**Consultation Response from KC,
Trees**

2025/92776 land at, Eastfield, Shepley, Huddersfield, HD8 8HB

Outline application, with all matters reserved, for residential development with associated open space, landscaping, drainage infrastructure and associated works

Date Responded: 21/11/2025

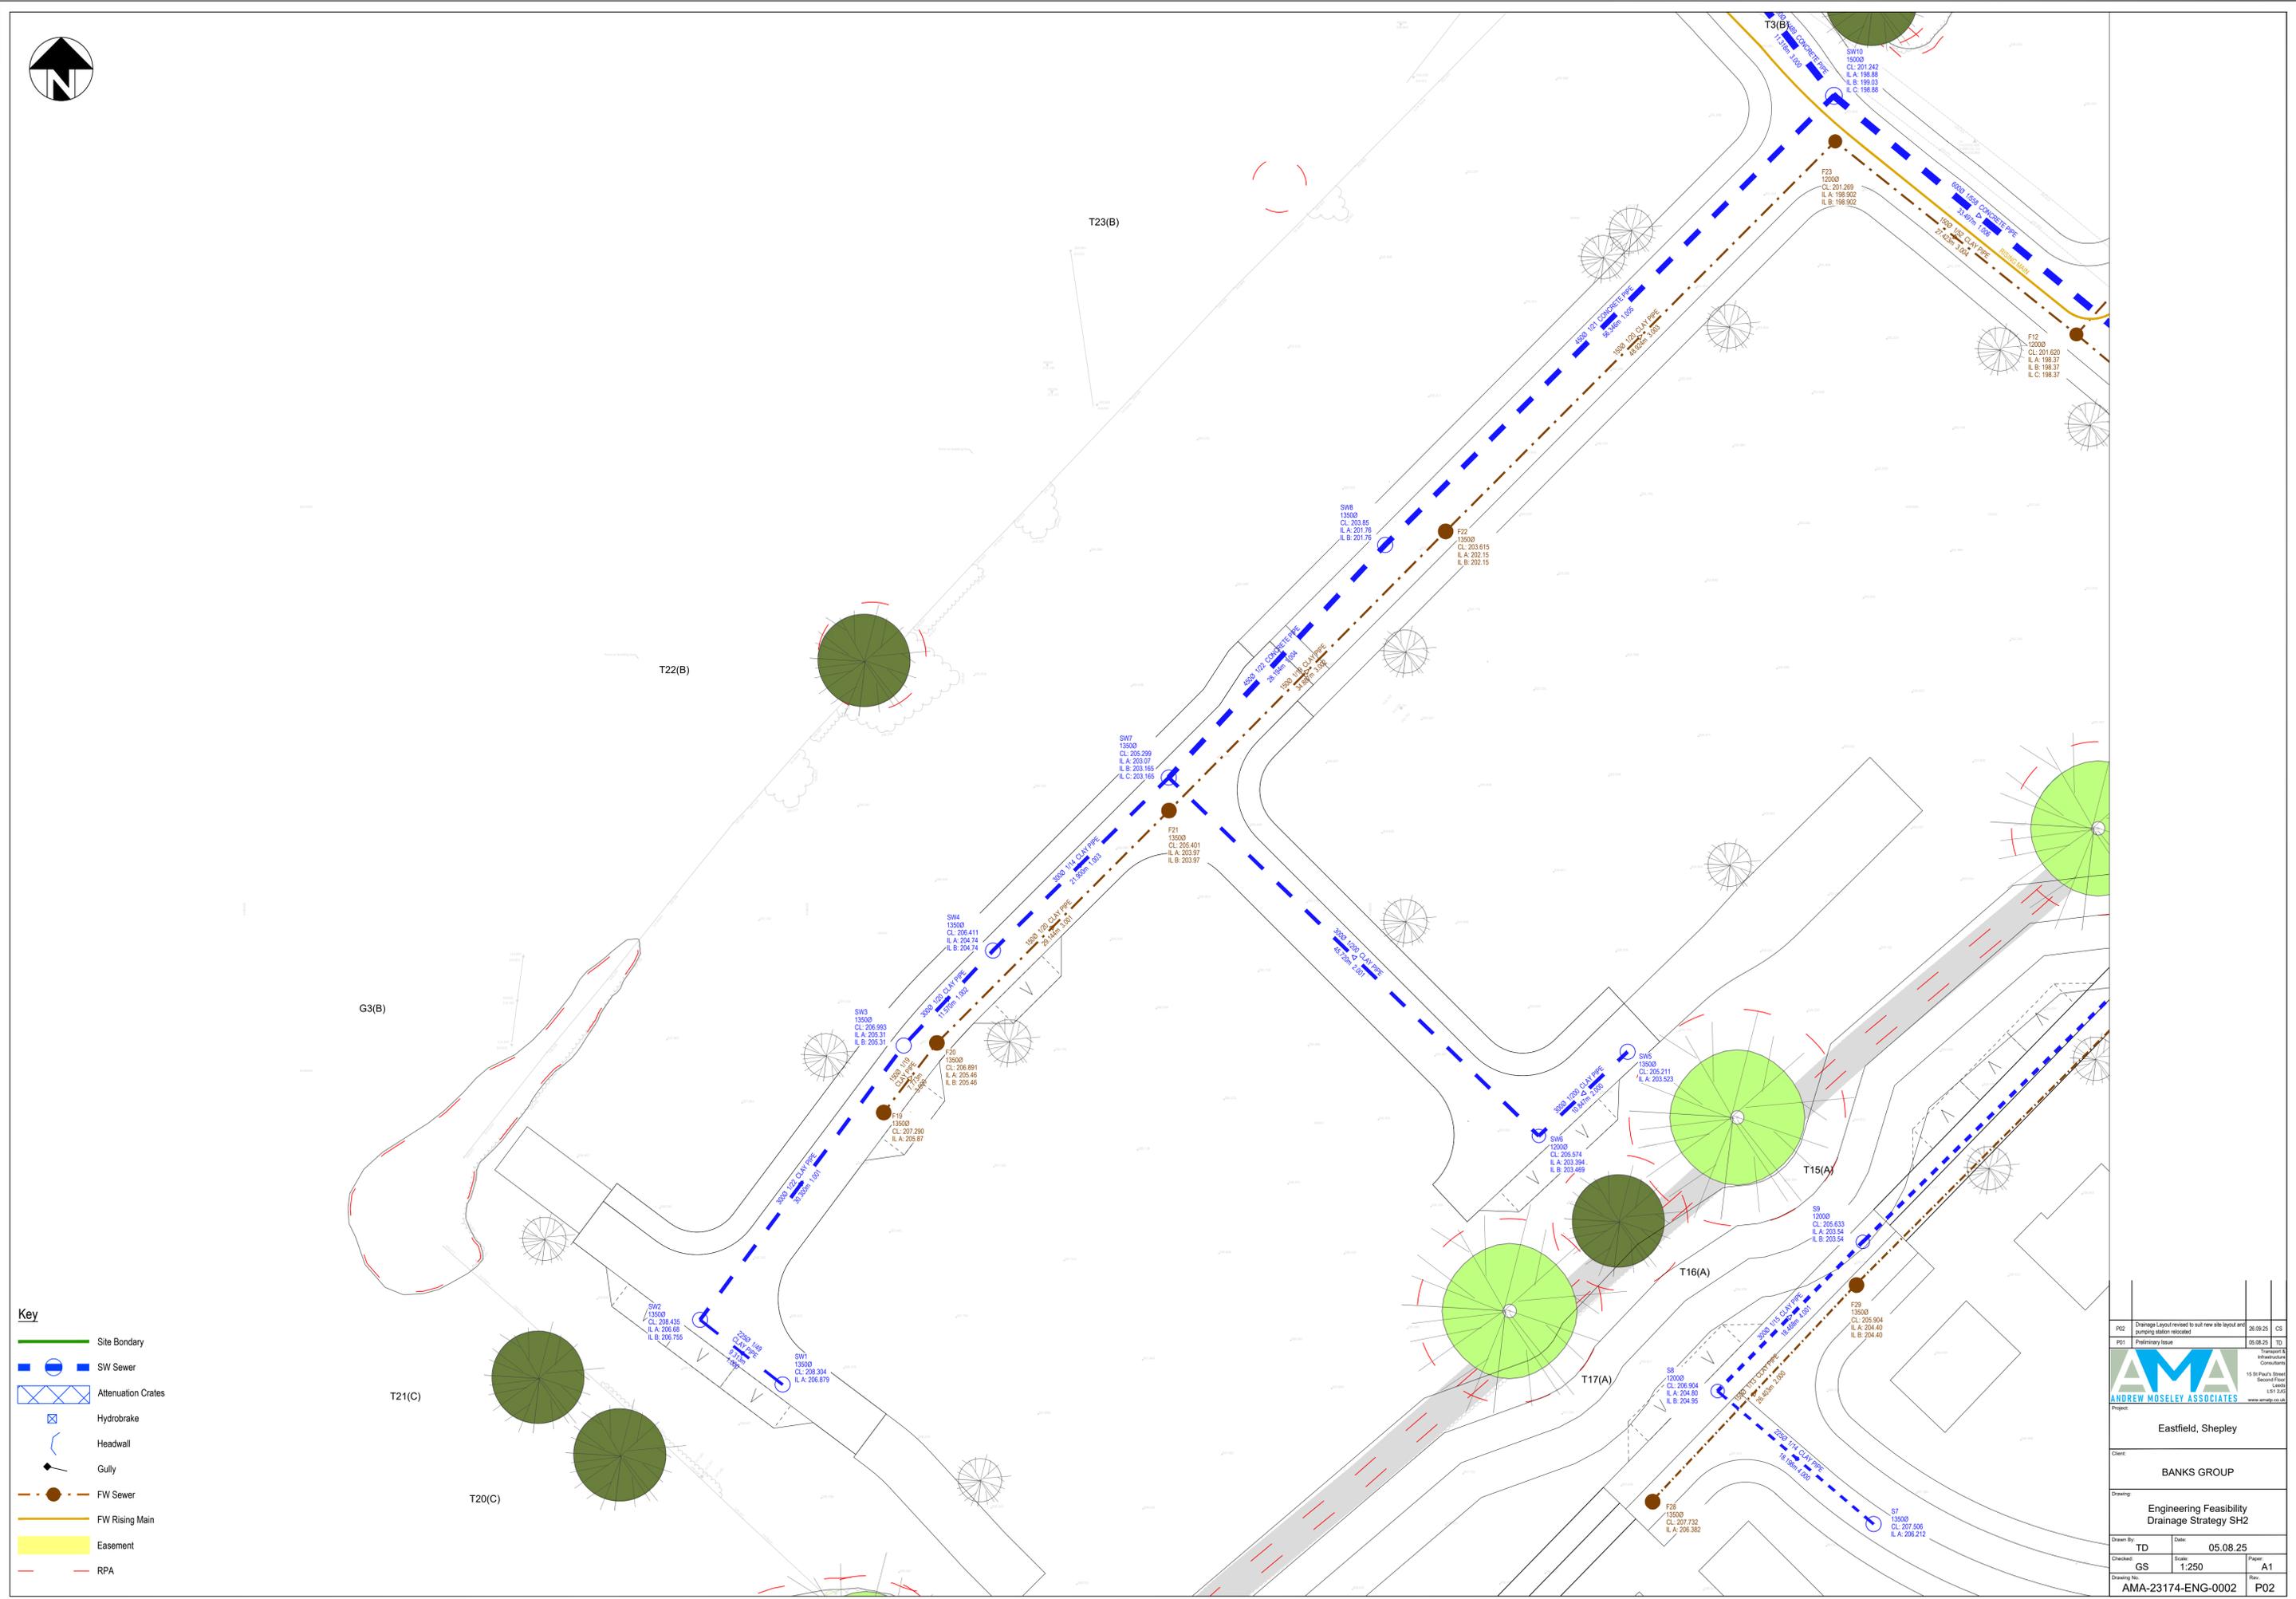
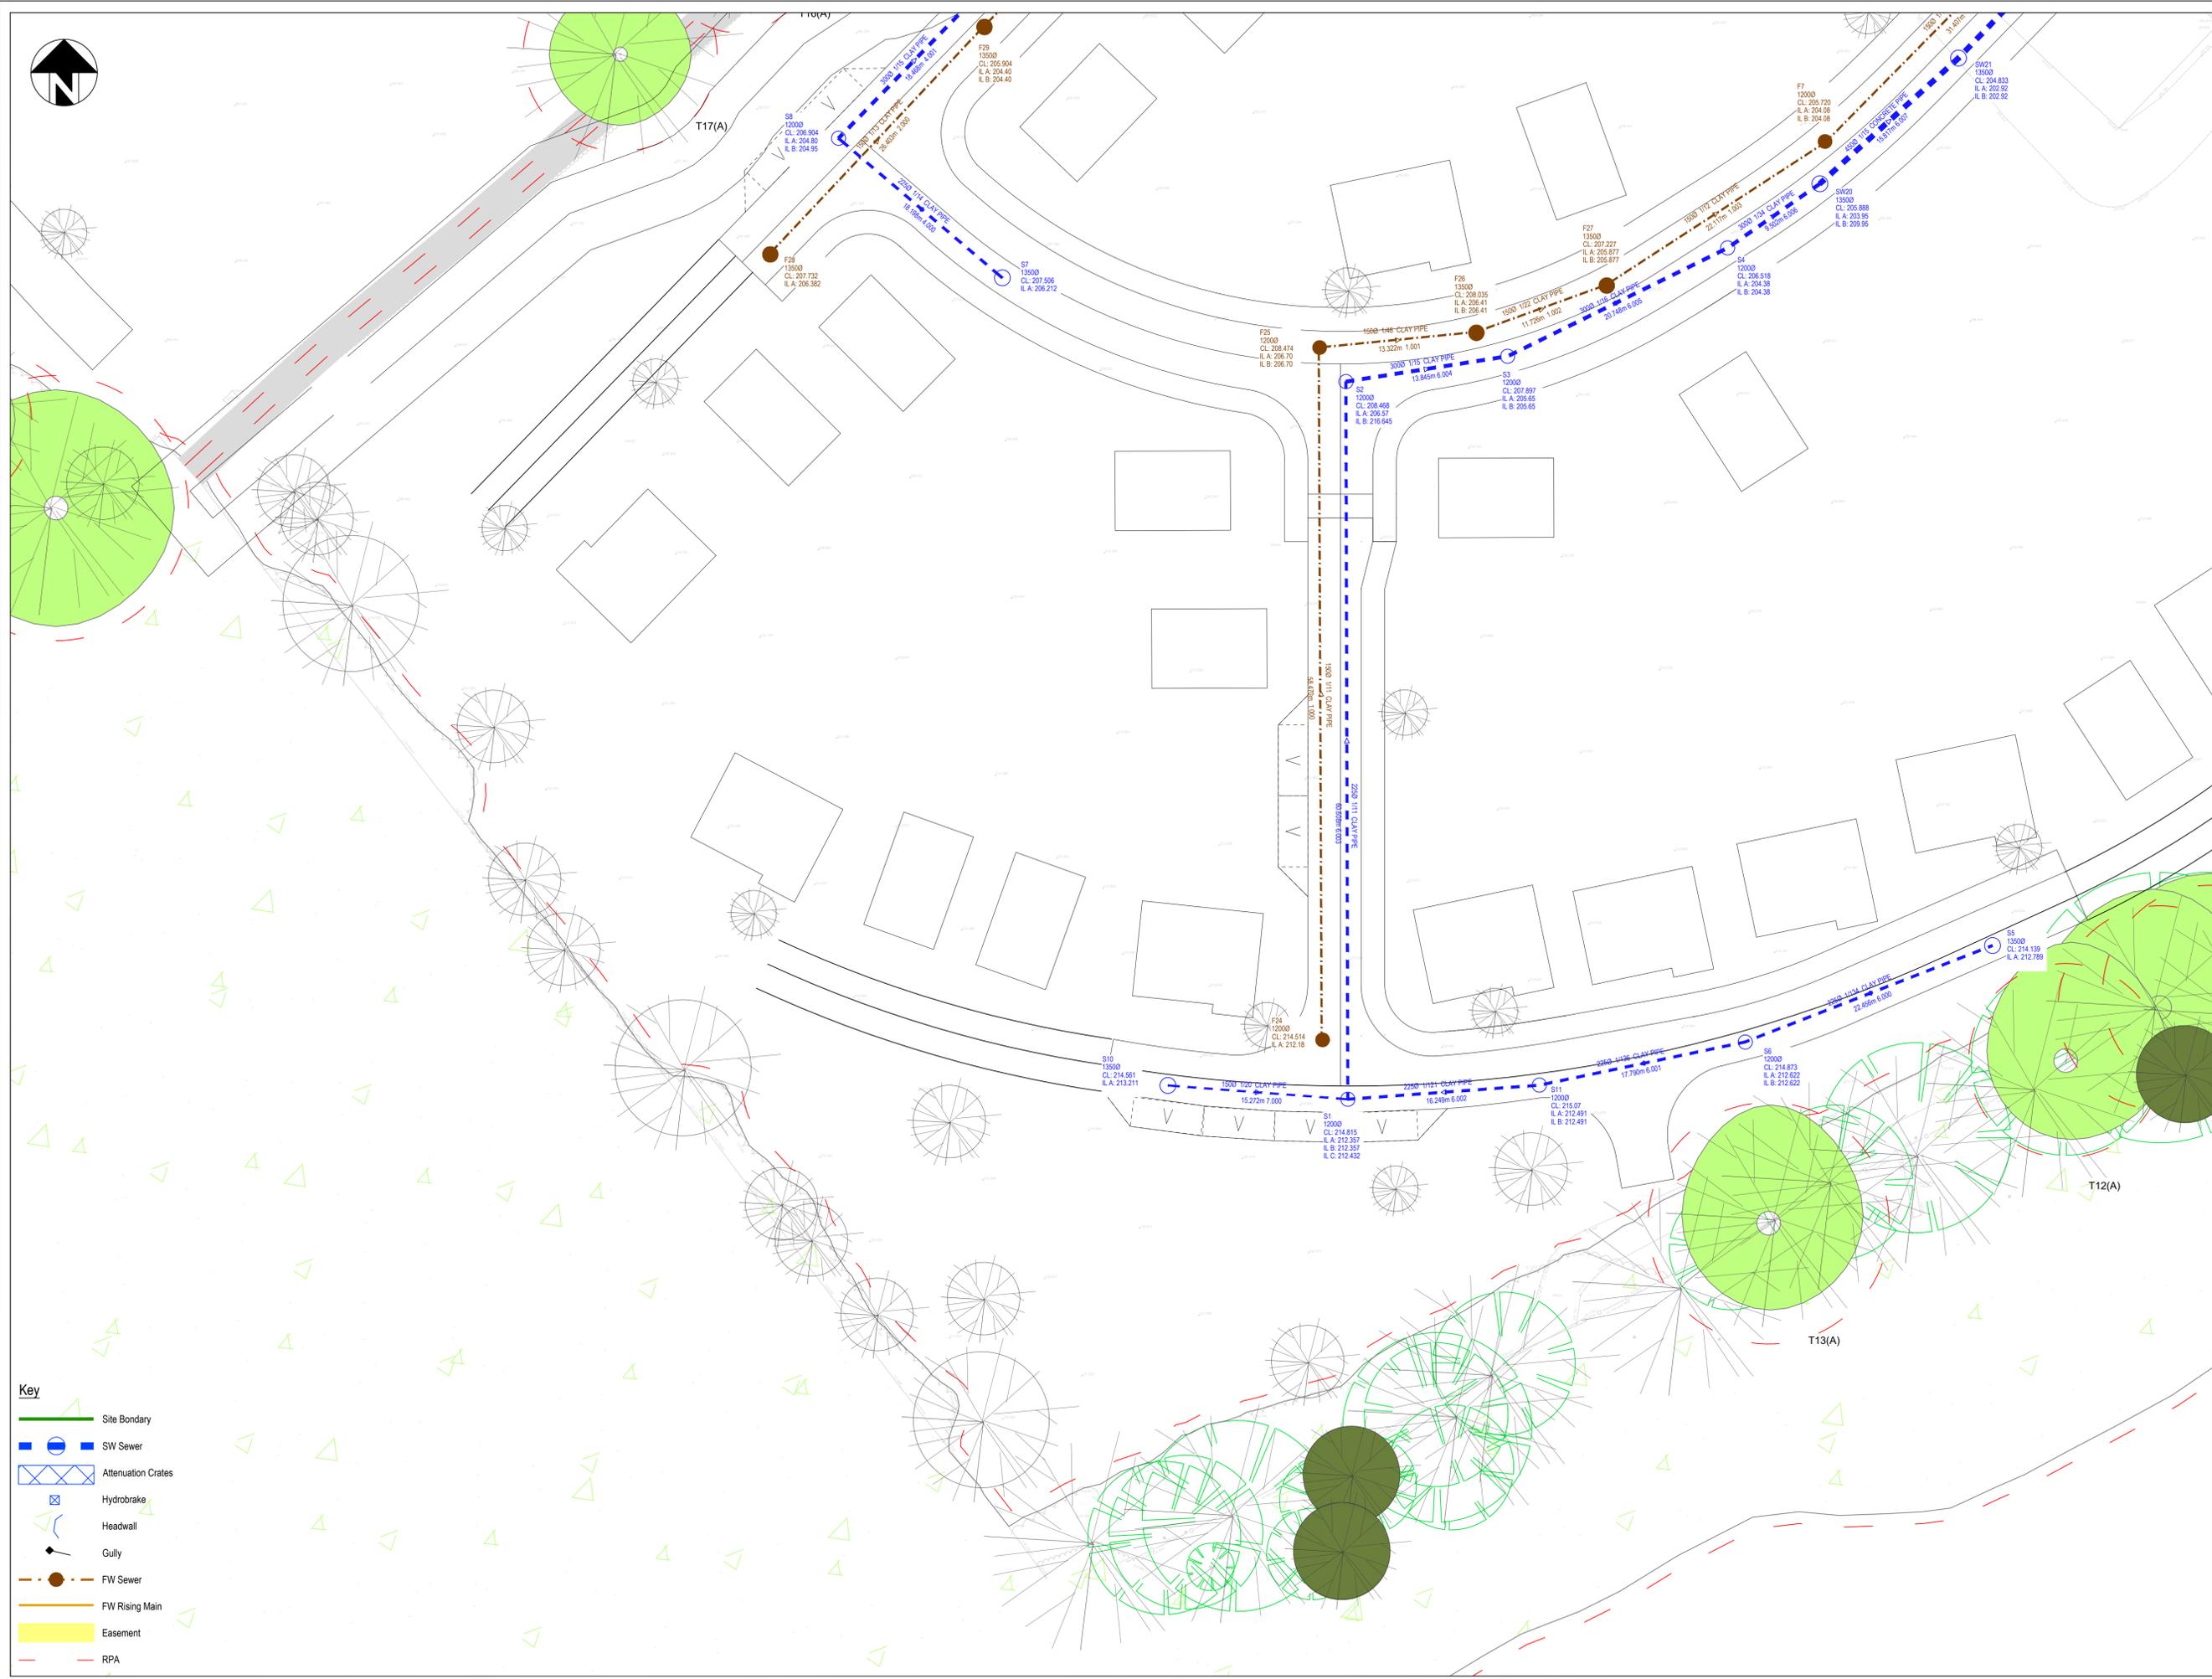
KC Trees cannot support the removal of T4, which is an ash of impressive girth and recorded veteran characteristics. With an estimated girth of almost 4m, by the Ancient Tree Forum and Royal Forestry Society guidance, this tree can be considered a veteran ash, which constitutes an irreplaceable habitat and must be retained within the proposals. The diameter has been estimated by the surveyor due to dense vegetation at the base, preventing access to the stem, therefore this tree will need to be resurveyed to allow an accurate RPA to be calculated. This is the largest, oldest and most ecologically valuable tree on the site. **The final layout will require the proposed pumping station to be sited outside of the RPA of the veteran tree.**
